STAIR LAYOUT

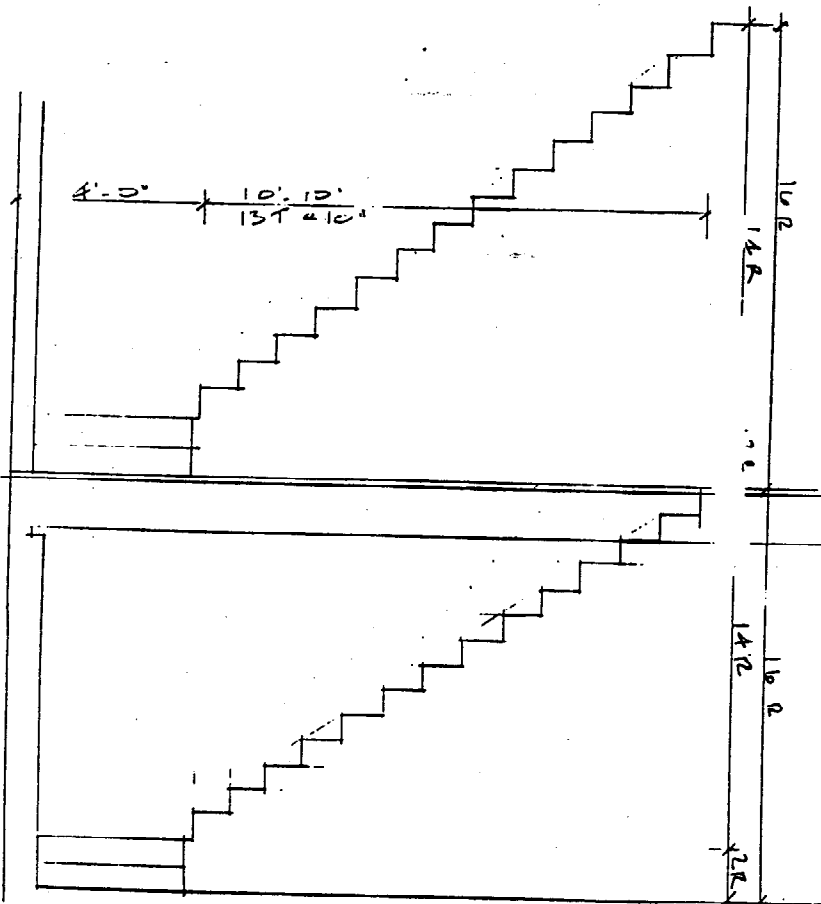
• STAIRS from document last stair does not meet

10/22/02 - Follow up (w/ Kevin Carril) all of the above issues have been corrected. LVL has lally column at each end. Ready for issuance of clo J.R.
